Re: URBAN APRATMENETS, 800 Silver Ave. SW
Grading and Drainage Plan
Engineer's Stamp Date 7/29/2013 (C18/D035)

Based upon the information provided in your submittal received 7-30-13, the above referenced Grading and Drainage Plan can not be approved for building permit based on the following comments:

# CONCEPTUAL GRADING PLAN

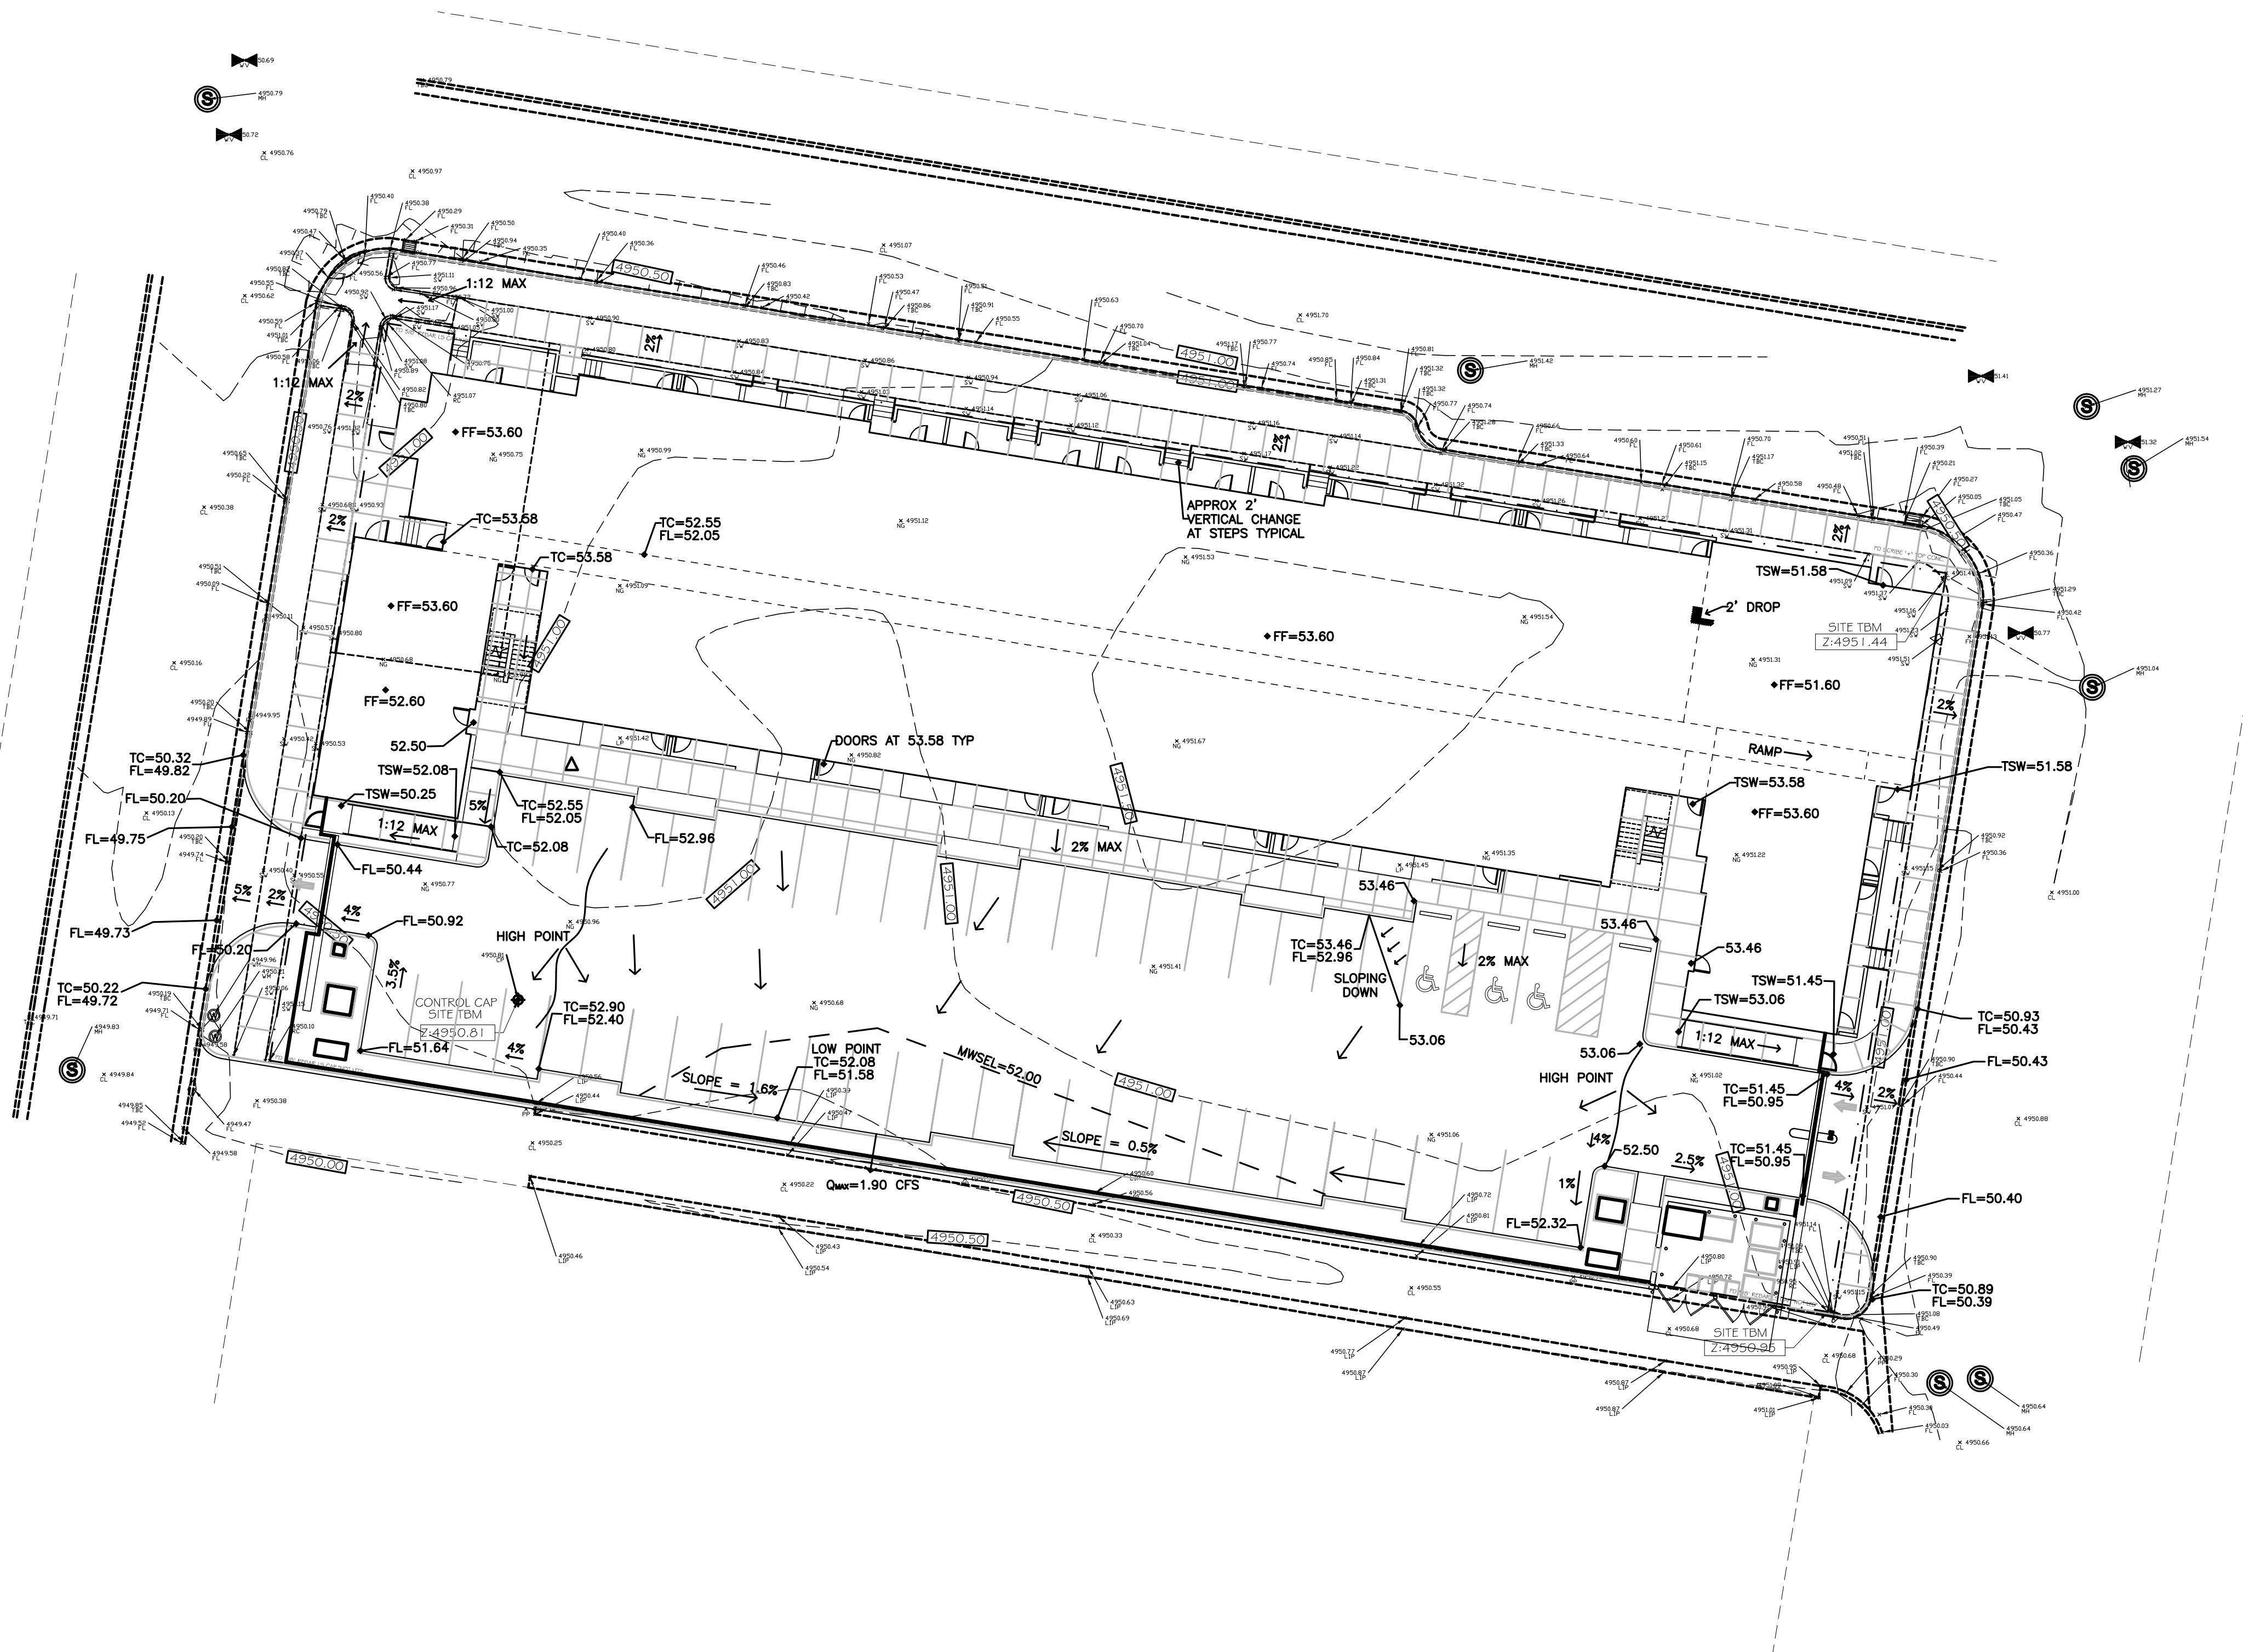
- Show top of curb and back sidewalk elevations along Silver Ave., 8th St., and 9th St. Is there an extended stem wall being proposed for the building? Is there any sidewalk connection from the building to the street?

- How will the sidewalk grades along 8th St. and 9th St. tie into the exiting alley? Provide detail grades.
- Provide spot elevation for the trash enclosure.

- Will retaining wall be required along the alley? In some areas the elevation difference between the alley and parking lot is close to 2'.
- Show the 100-year WSEL in the parking area. The minimum top of curb elevation should be the same or higher than the 100-year WSEL.

- Is sidewalk culvert required or the runoff can simply discharge through an opening in the header wall. What is the size of the orifice? Provide detail for the sidewalk culvert and the orifice. The plan shows a discharge of 0.96 cfs from the parking lot to the alley and the AHYMO run shows the discharge at 1.763 cfs.

- Is the alley paved? If not, the construction plans for paving the alley must be submitted to DRC.
- Provide additional spot elevation closer to the easterly entrance to assure proper water block is provided.
